**From:** Planning  
**Subject:** FW: St James' Clitheroe

**From:** Woosey, Carole <[Carole.Woosey@environment-agency.gov.uk](mailto:Carole.Woosey@environment-agency.gov.uk)>  
**Sent:** 19 November 2021 10:31  
**To:** John Macholc <[John.Macholc@ribblevalley.gov.uk](mailto:John.Macholc@ribblevalley.gov.uk)>  
**Subject:** St James' Clitheroe

Project Title  
**Proposed New Build  
Sections**

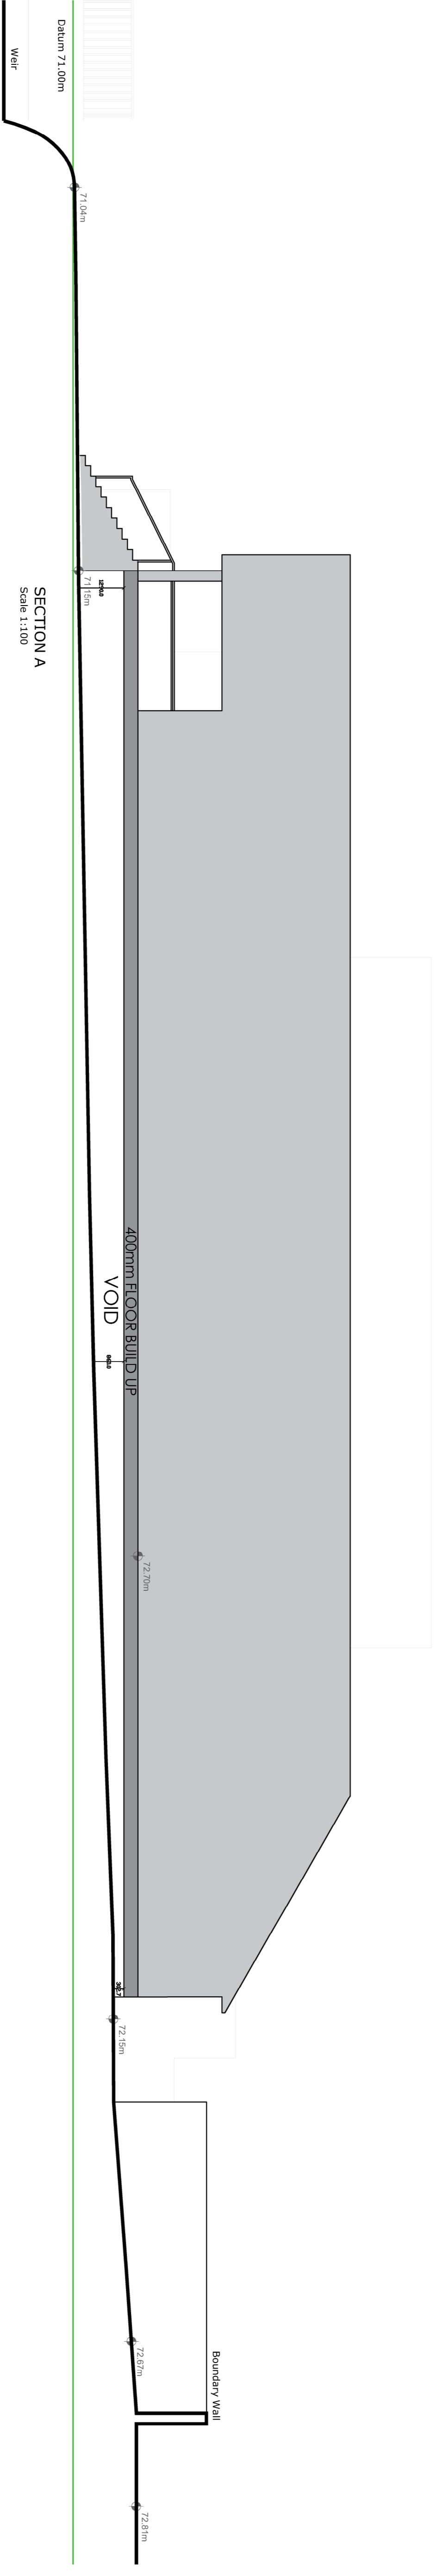
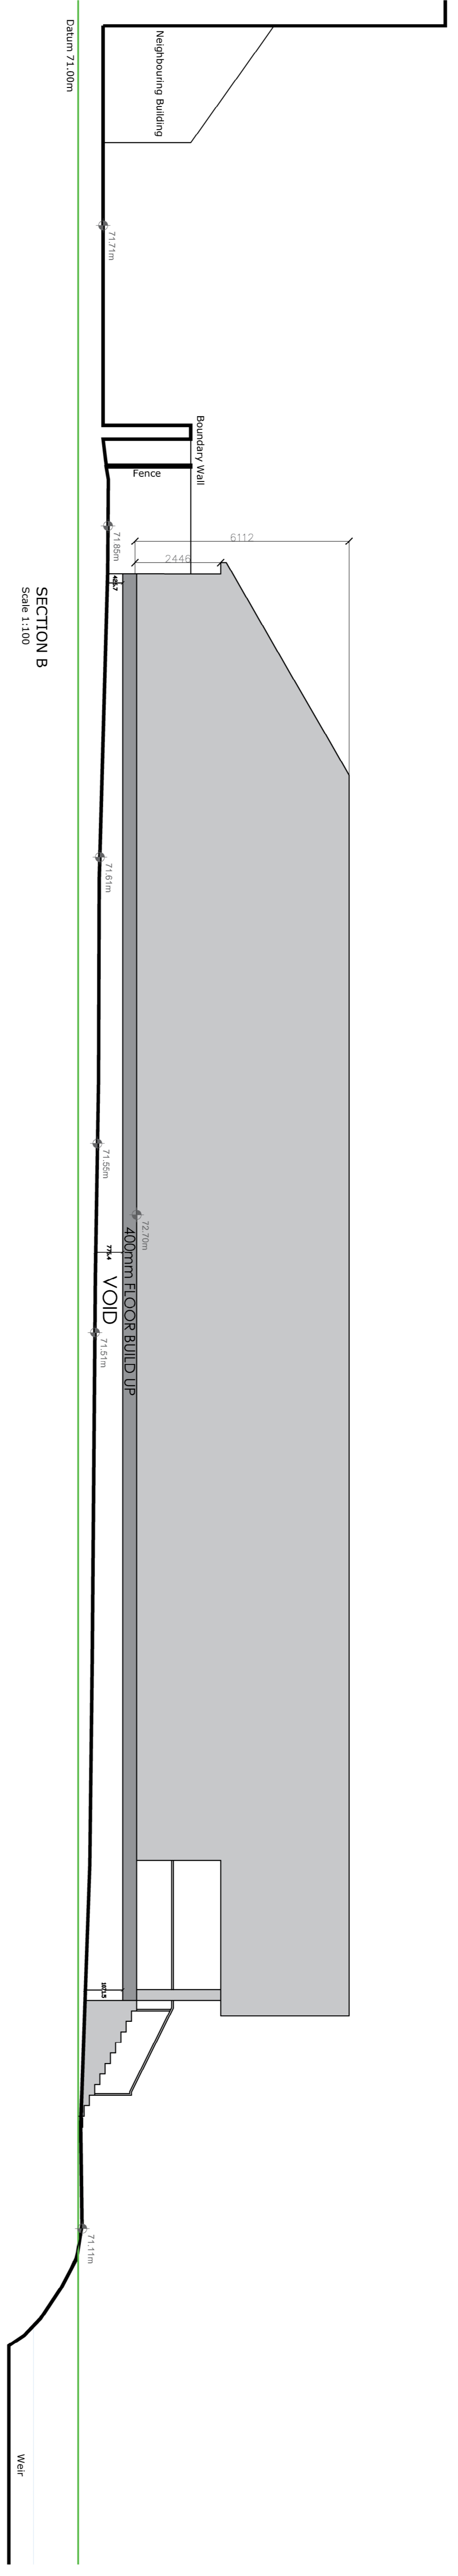
Unfortunately, the technical team remain to be convinced that the scheme can work without pushing flood risk elsewhere and have asked me at this stage to maintain the objection. They are asking for modelling to be done to demonstrate that the pillars beneath the new building won't cause blockages and divert flood flows to the surrounding houses.
